**PRELIMINARY DRAINAGE REPORT  
FOR  
STERLING RANCH PHASE 2 PRELIMINARY PLAN**

**Engineering Review**

**October 1, 2020  
Project No. 25188.02  
SP-20-003**

**LEGEND**

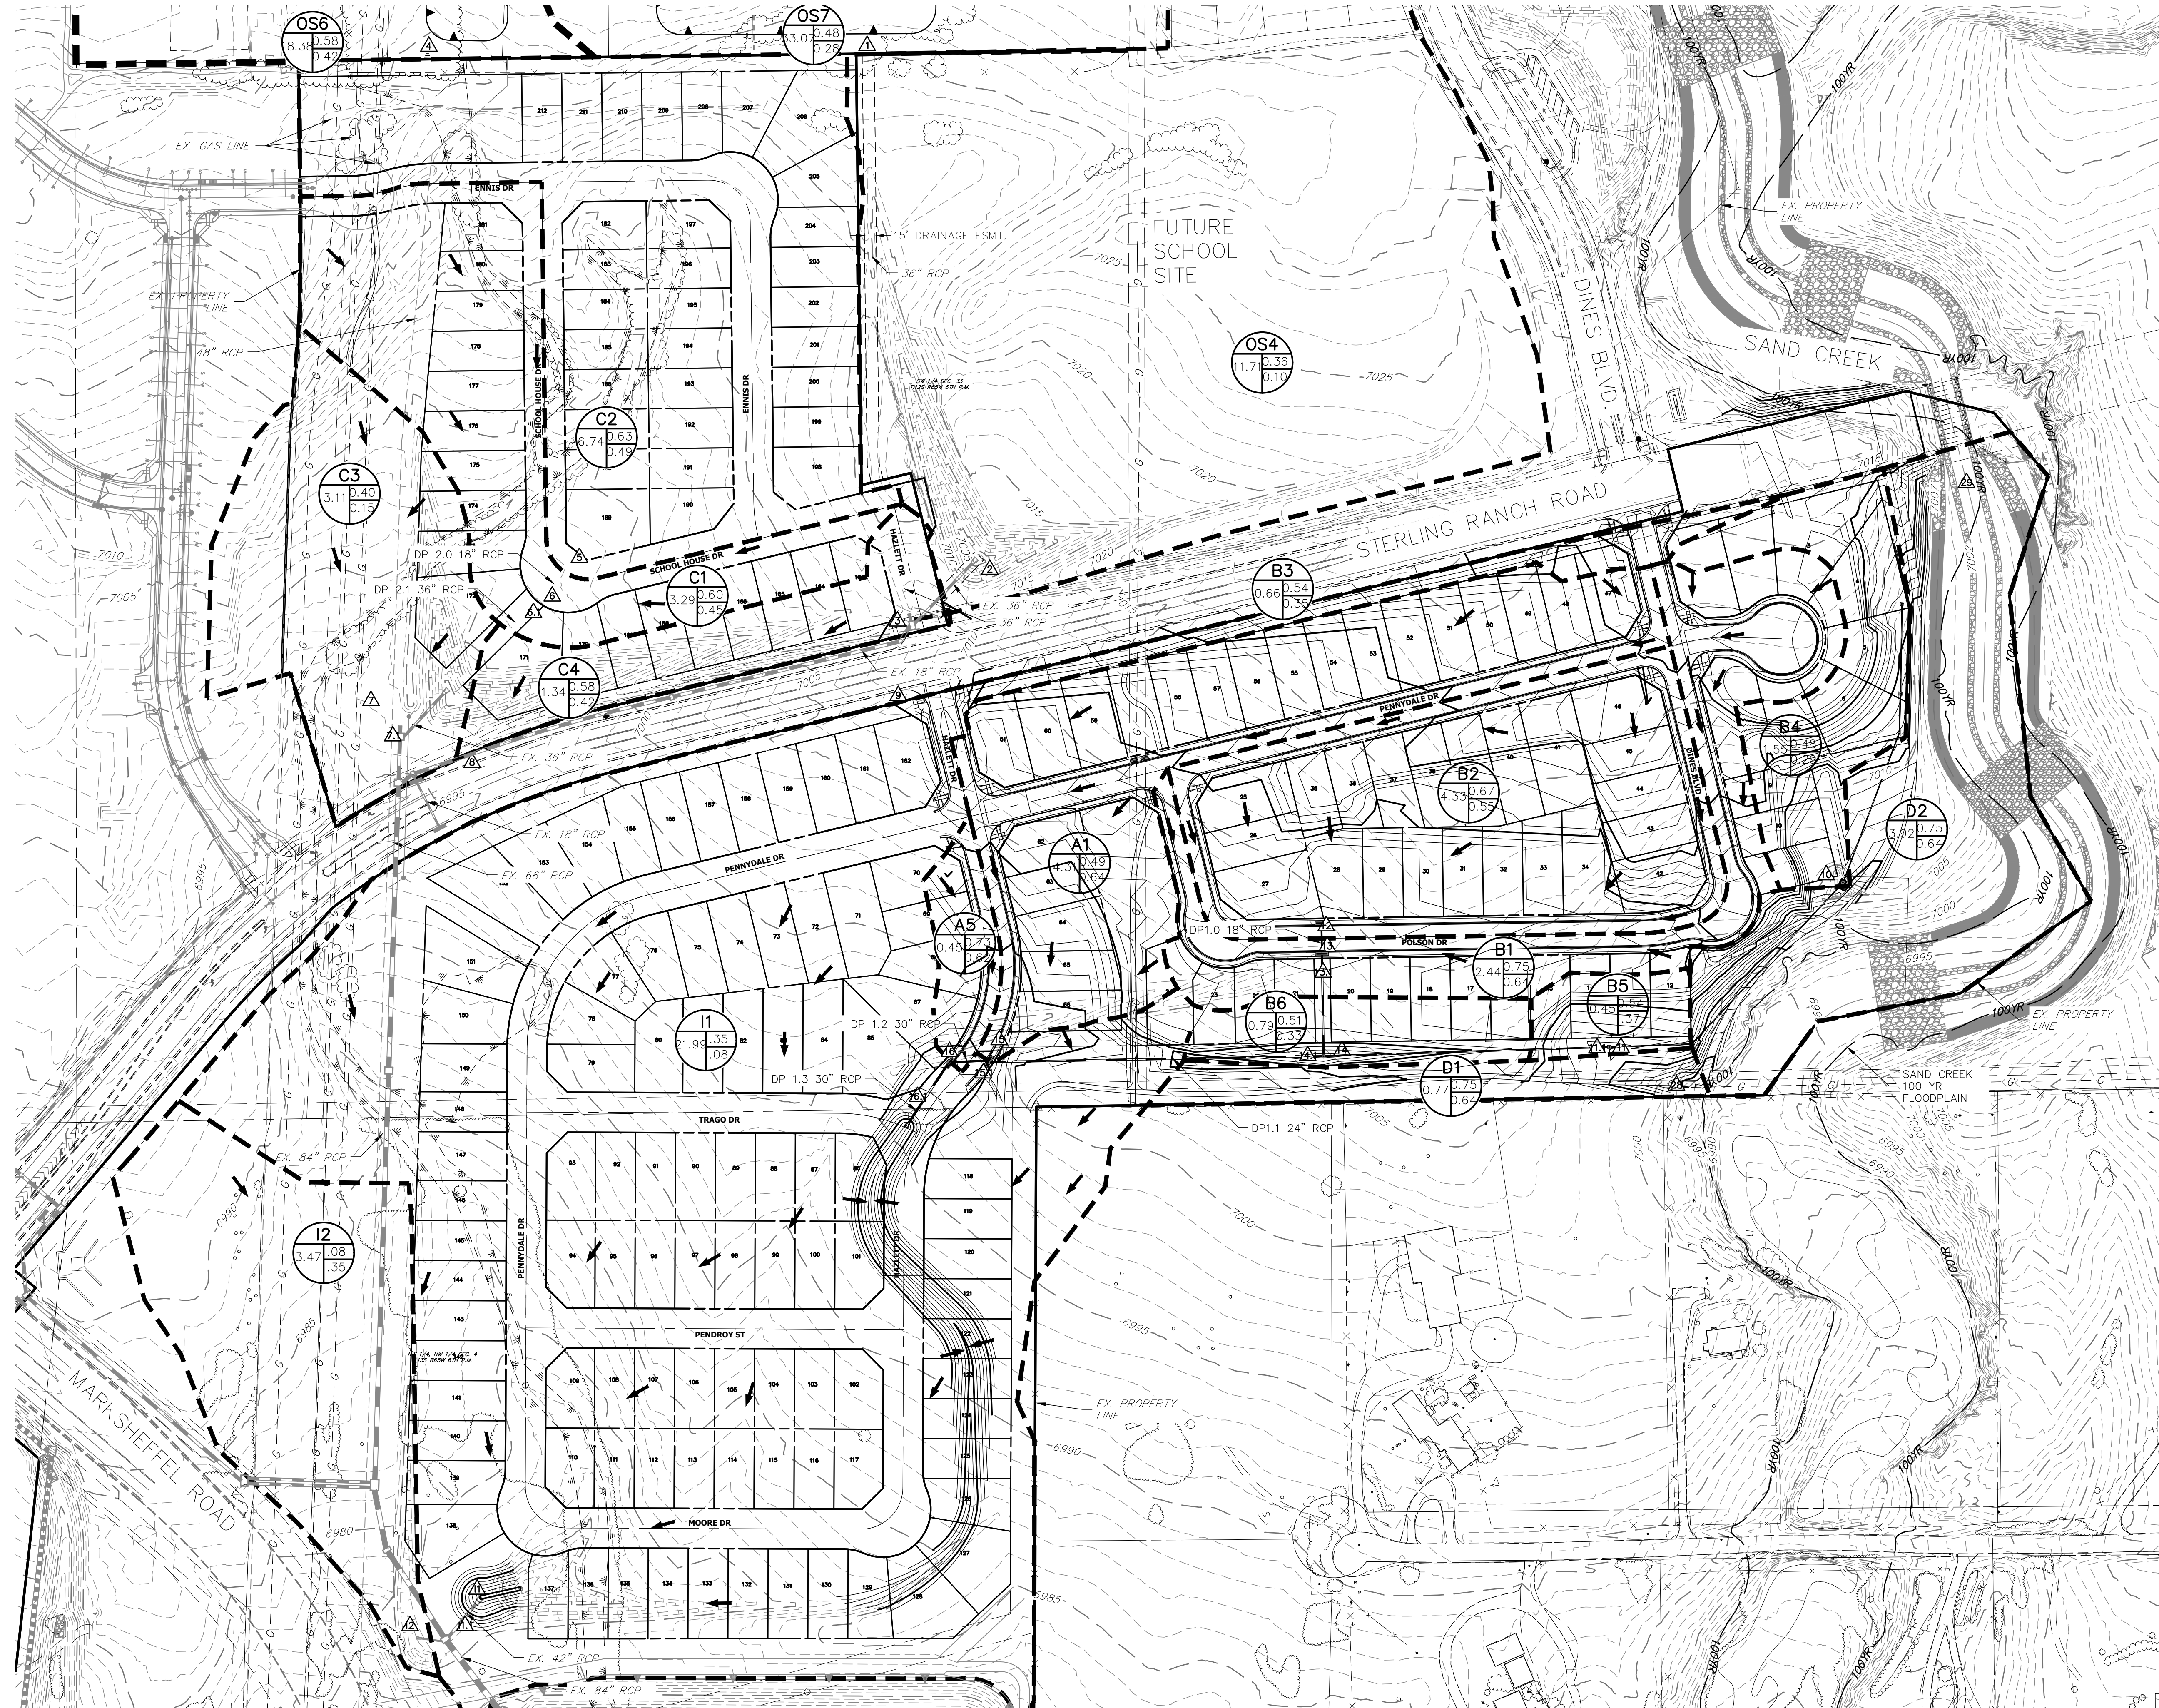
15?

basin?

bypass?

17?

basin?

20?

22?

bypass?

16?

19?

pipe

21?

24?

25?

13?

12?

adjust plan location?

adjacent properties and

southwest and (?)

4?

1?

JR Response: Yes, upstream bypass flows

JR Response: updated

JR Response: Updated

JR Response: Updated

JR Response: Updated

JR Response: Updated

JR Response: Updated

JR Response: Updated

JR Response: Updated

JR Response: Updated

JR Response: Updated

JR Response: Updated

JR Response: Updated.  
Southeast only.

JR Response: Updated

JR Response: Updated
